Vicinity Map

Vicinity-Location Map_V1.pdf Markup Summary

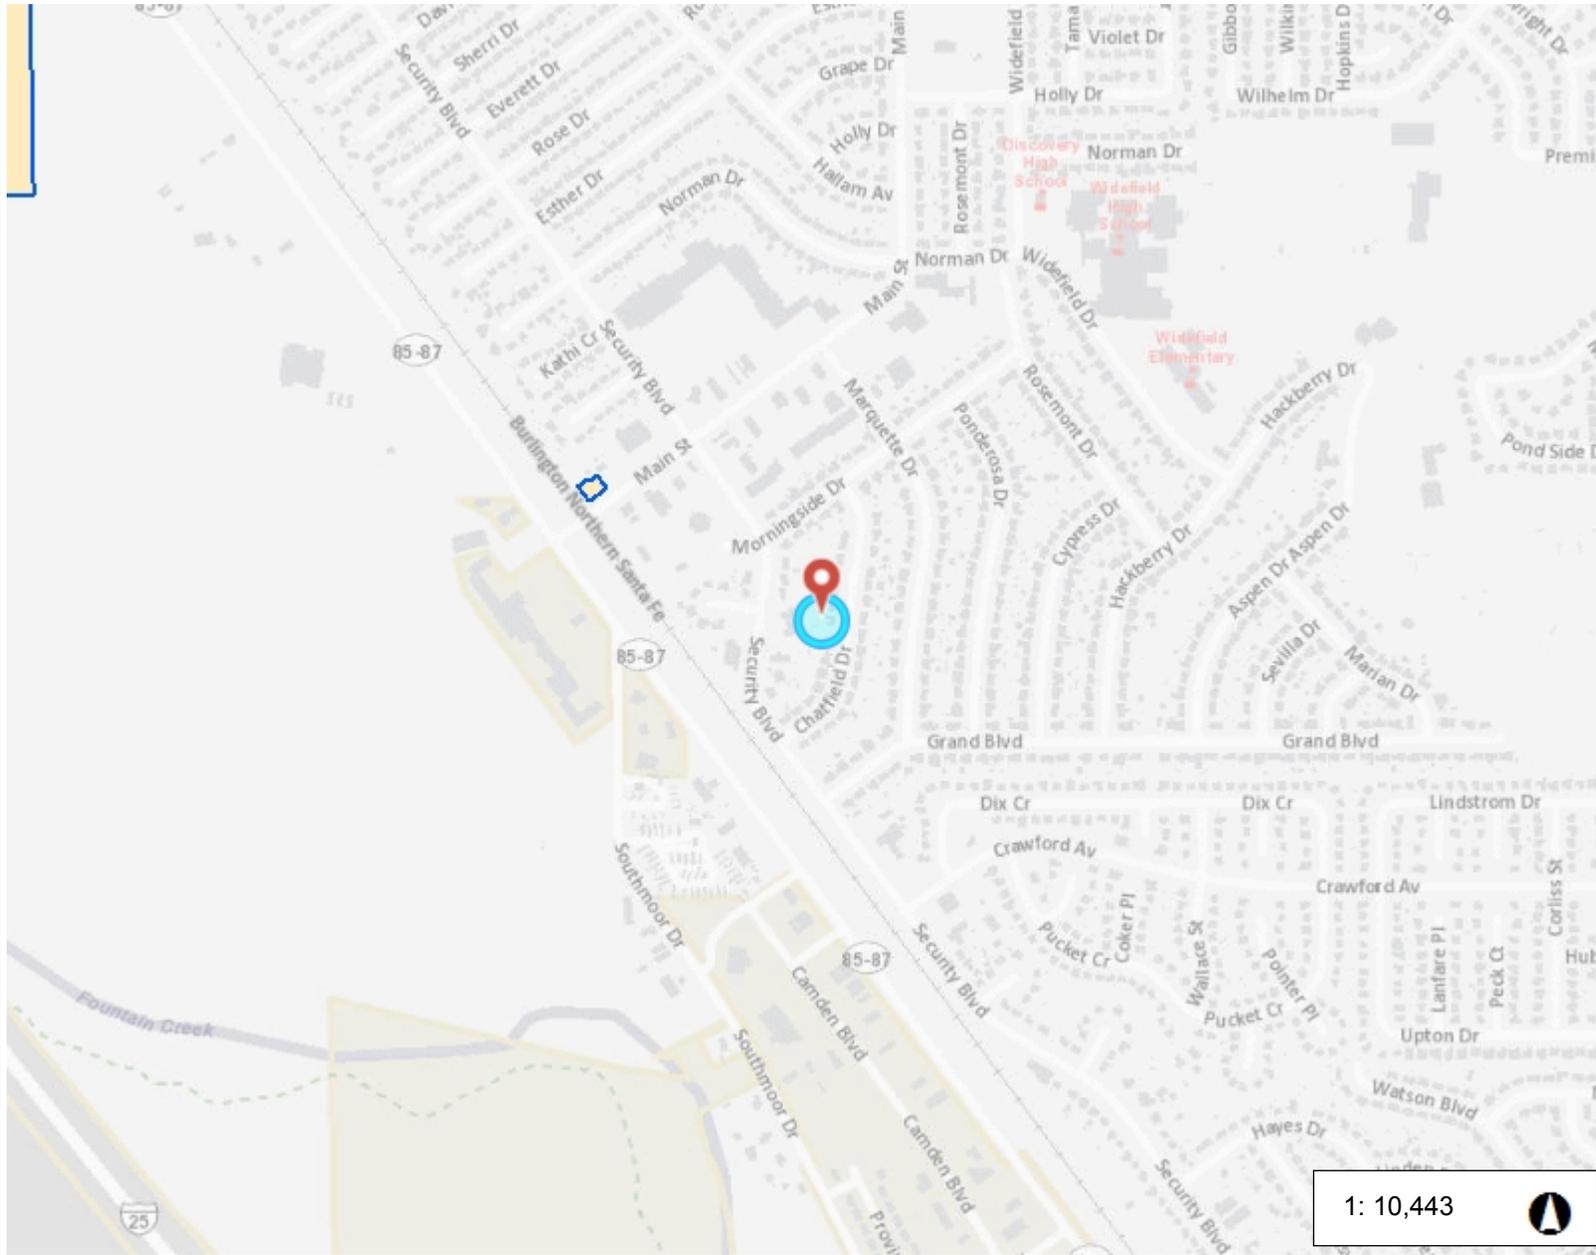
Please provide a Vicinity map that specifies the exact location of the subject property in relation to surrounding properties and roadway connections. A Vicinity Map should give the general public a serviceable understanding of the location of the property within the larger surrounding neighborhood. The map should be drawn at an appropriate scale and be oriented with north to the the top of the page.

Please provide a Vicinity map that specifies the exact location of the subject property in relation to surrounding properties and roadway connections. A Vicinity Map should give the general public a serviceable understanding of the location of the property within the larger surrounding neighborhood. The map should be drawn at an appropriate scale and be oriented with north to the top of the page.
